**M12 Motorway (SSI 9364)
Advice on Amendments and Response to Submissions**

I am writing to you in reply to your invitation to the Environment Protection Authority (EPA) to provide comment on the Amendments and Response to Submissions (RtS) for the above project.

ALEKSANDRA YOUNG
Unit Head
Regulatory Operations Metro South

Figure 6-1 Moderate to high ranked AEIs and potential fill areas

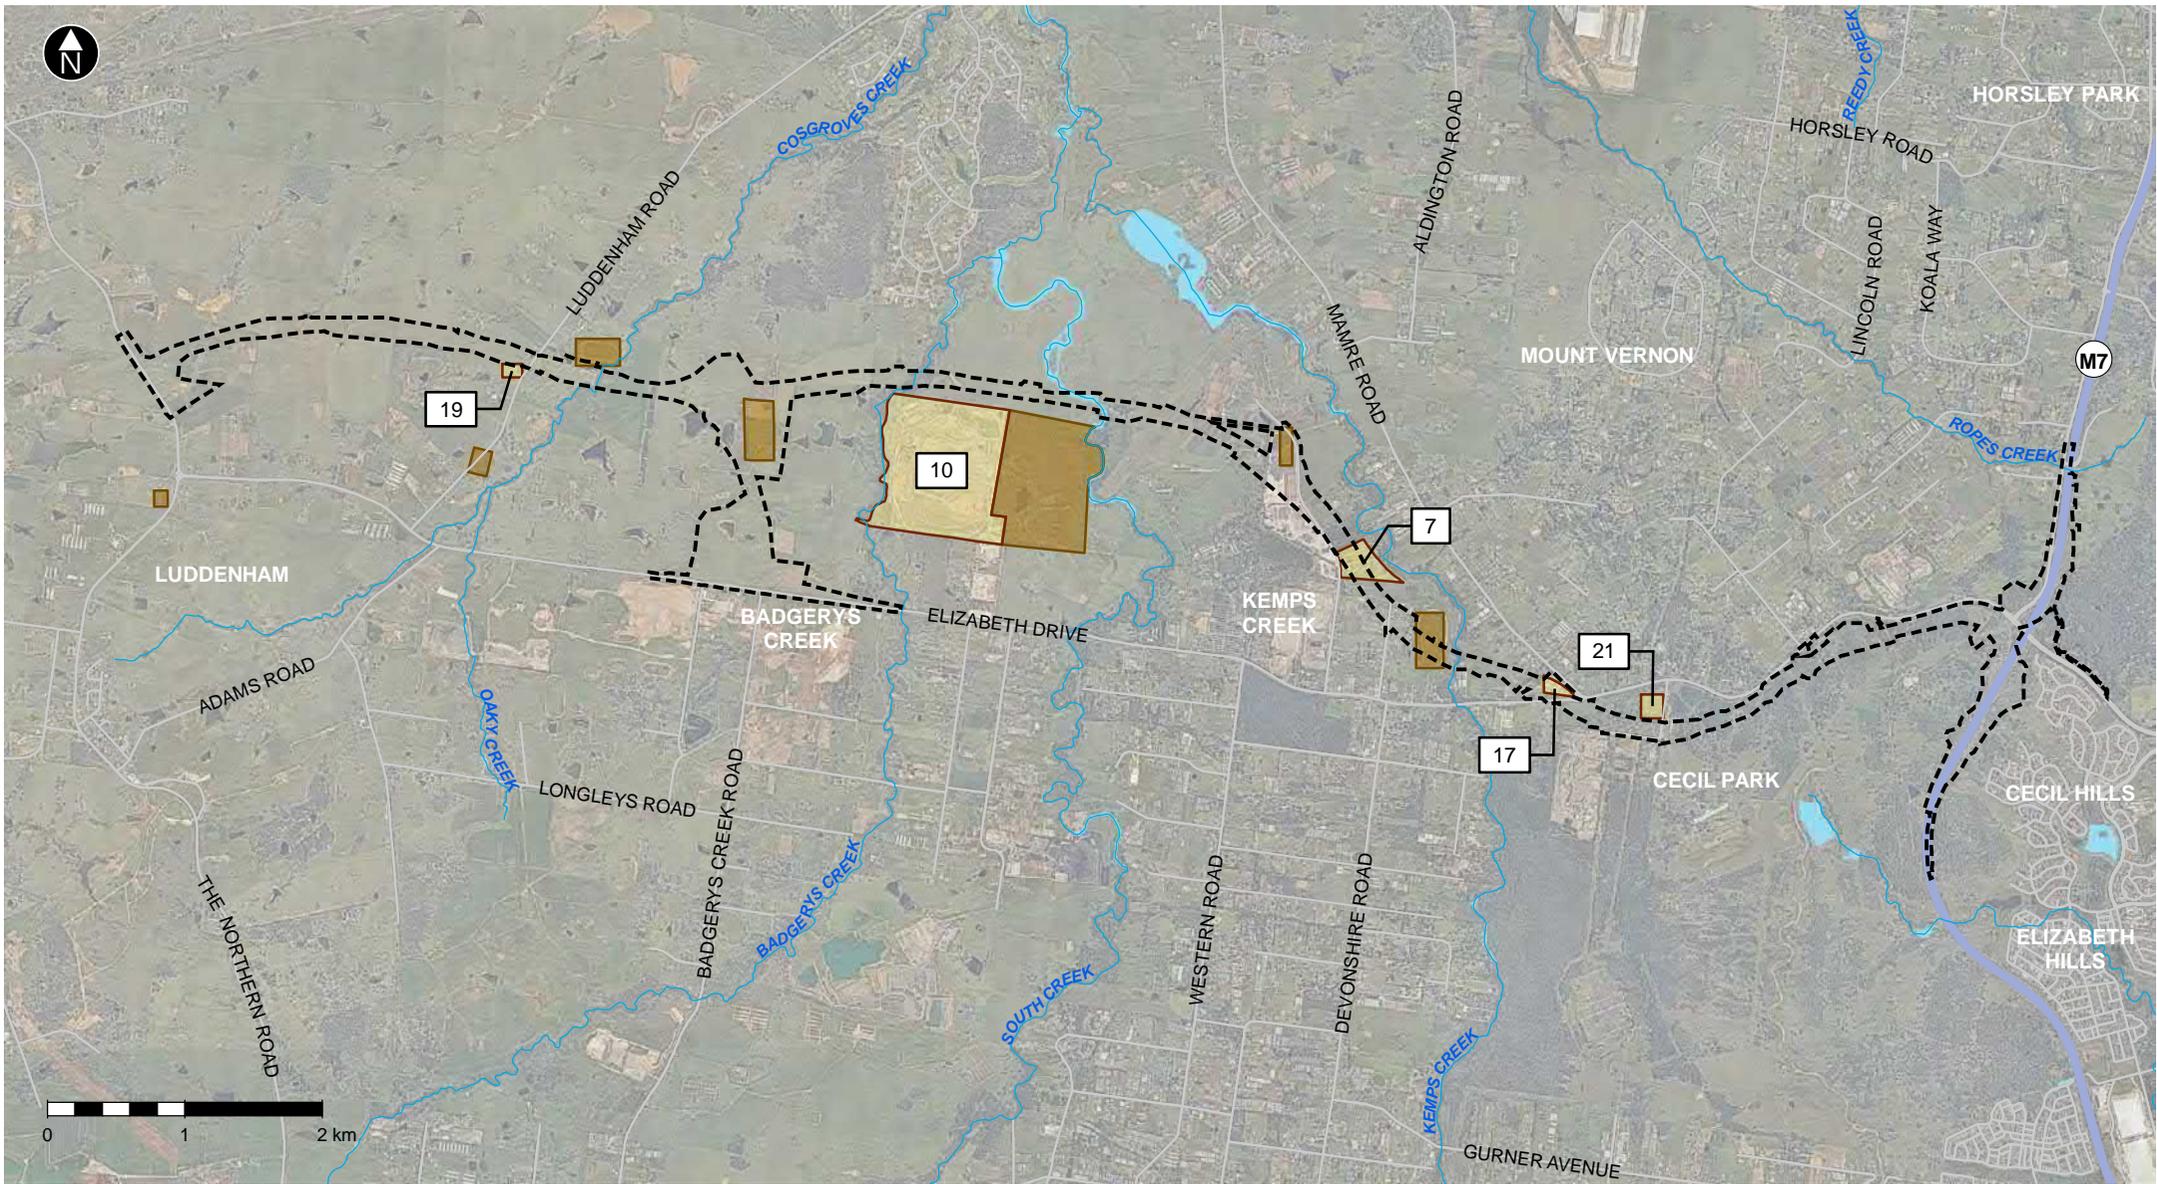
3. Prior to the commencement of any works that would result in the disturbance of potential or contaminated soils and groundwater at the areas of environmental interest identified in Table 6-60 of the *Amendment Report* (October 2020), detailed site investigations (for contamination) must be conducted to determine the full nature and extent of the contamination at the project area. The **Detailed Site Investigation Reports** (for contamination) and the subsequent report/s, must be prepared, or reviewed and approved, by consultants certified under either the Environment Institute of Australia and New
